Application by Highways England for A47 Wansford to Sutton Dualling

The Examining Authority's written questions and requests for information (ExQ1)

Issued on 16 December 2021

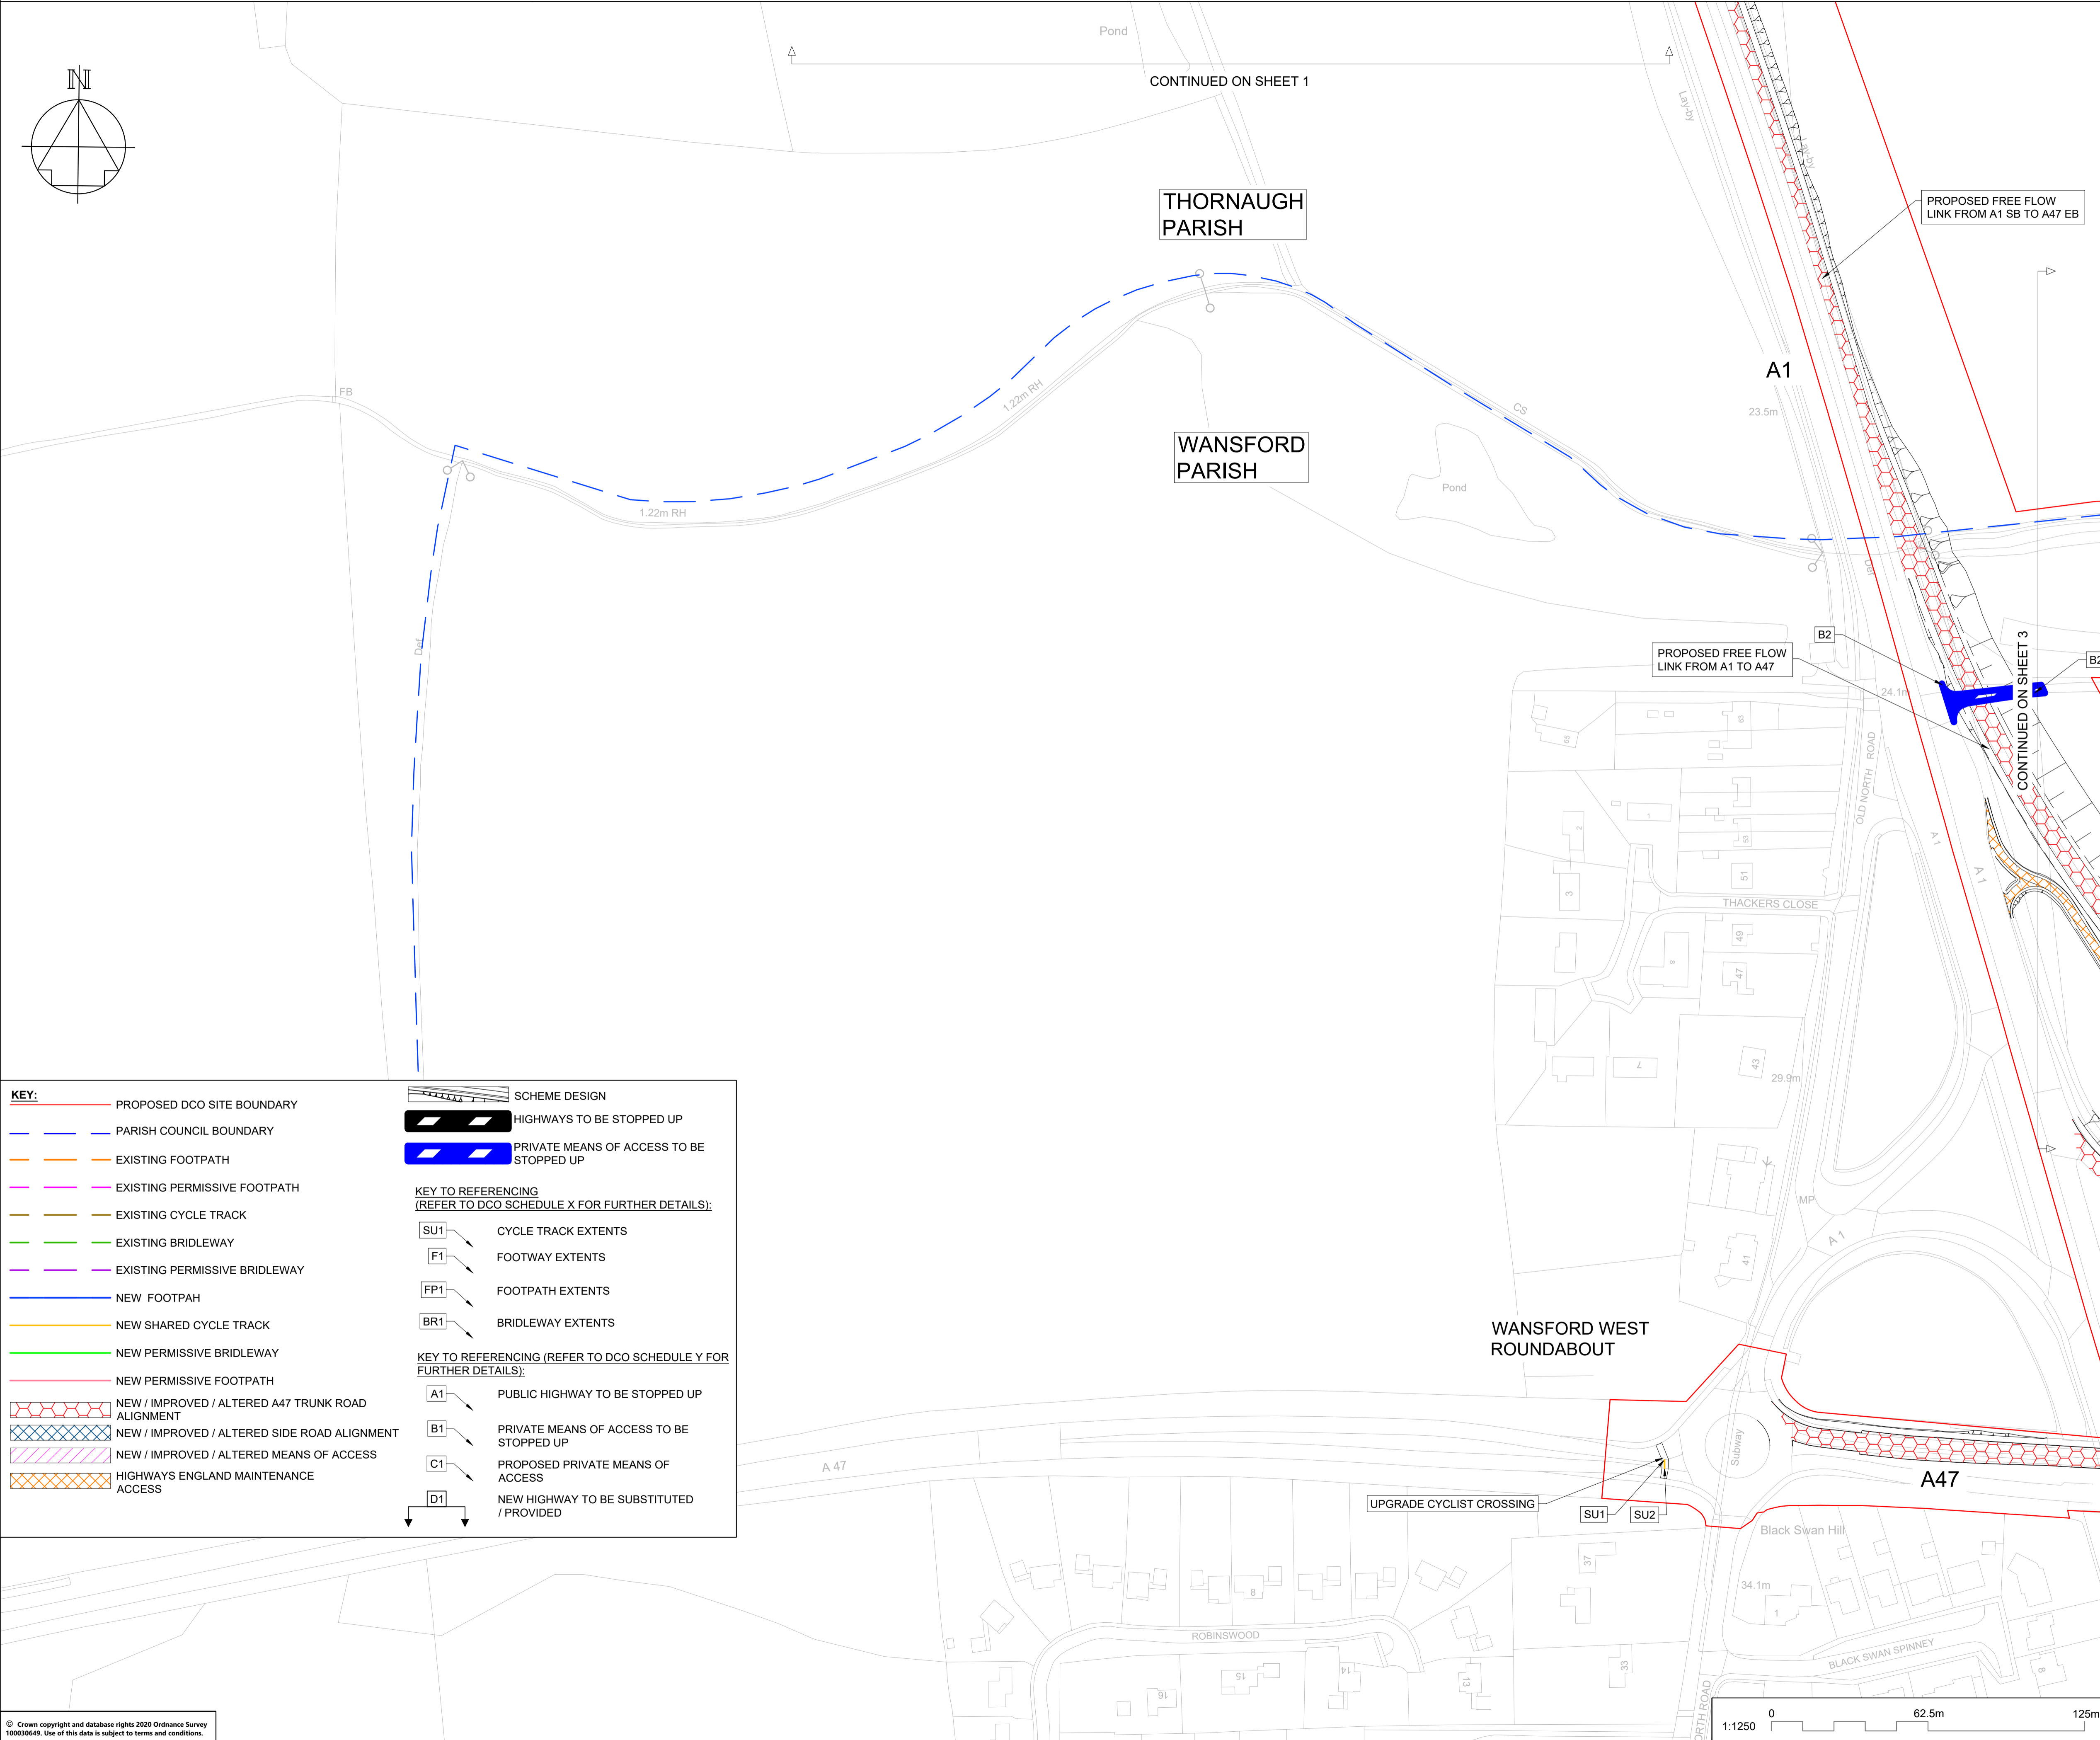
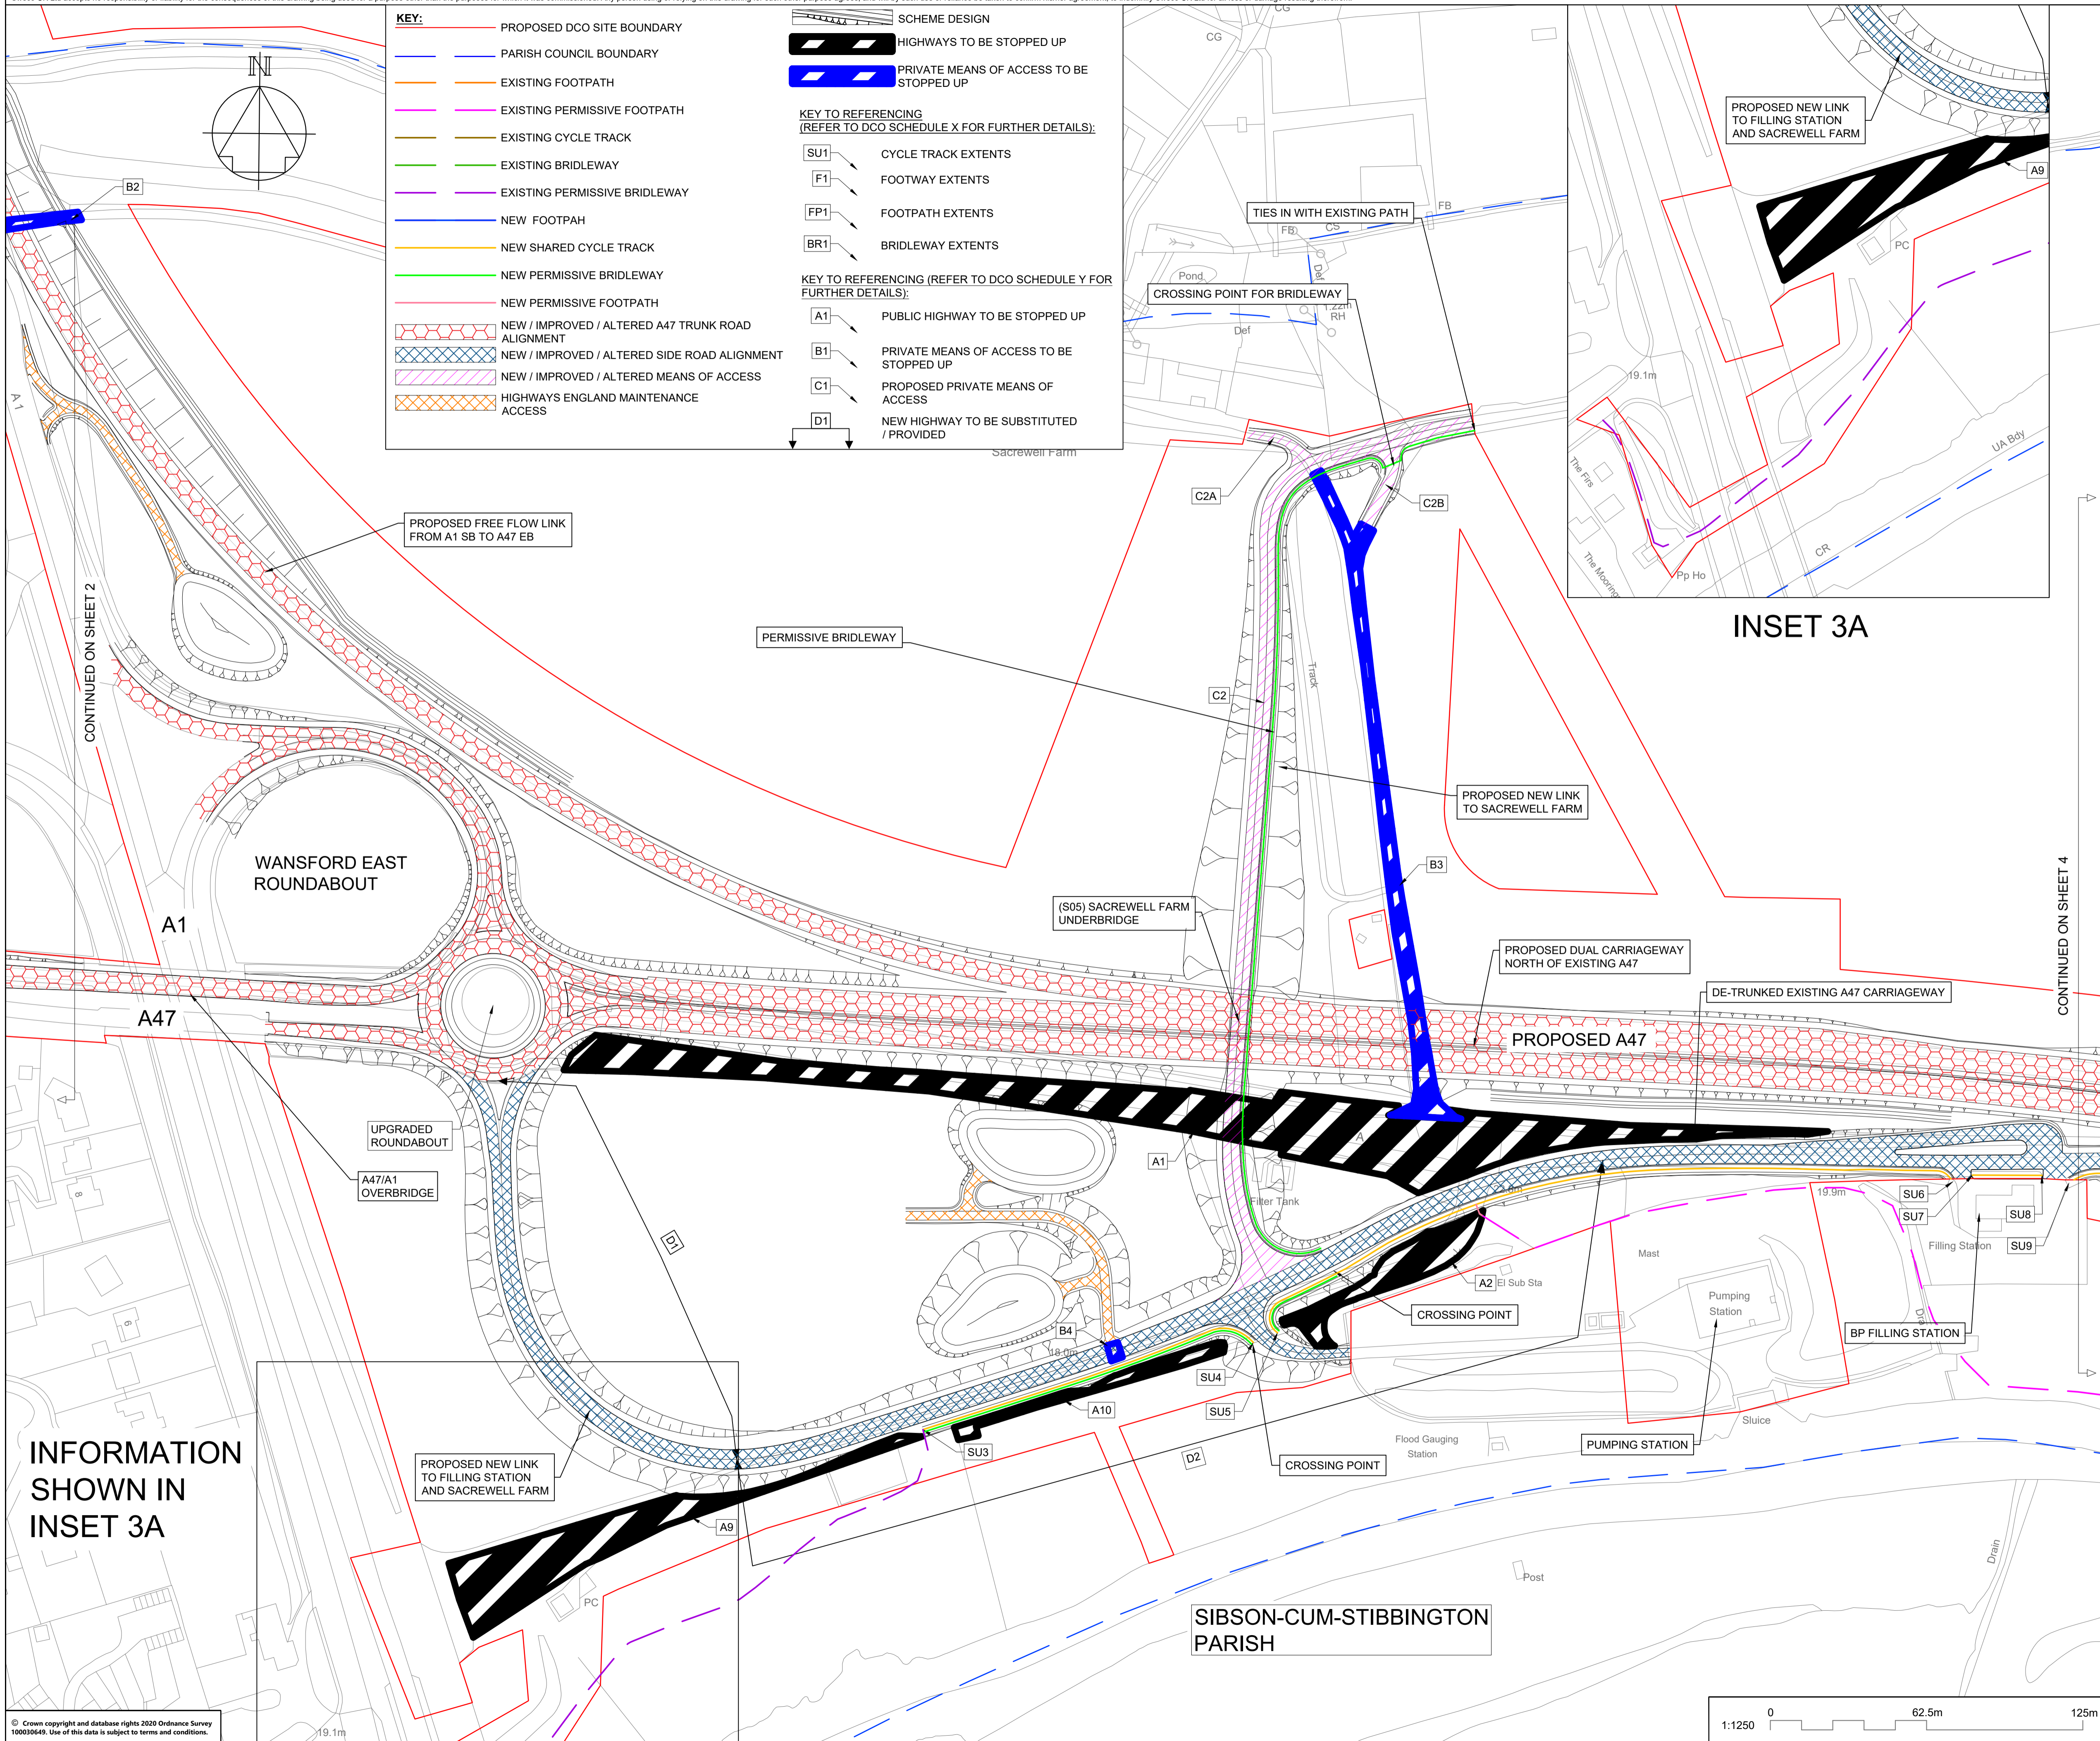
1.0.8.	The Applicant	Rights of Way and Access Plans a) Key has Schedule X and Y – please amend. b) Some drawings are titled “Rights of Way and Access Plans” and other “Public Rights of Way and Access Plans” – is there a reason for this or should/ can this please be made consistent?
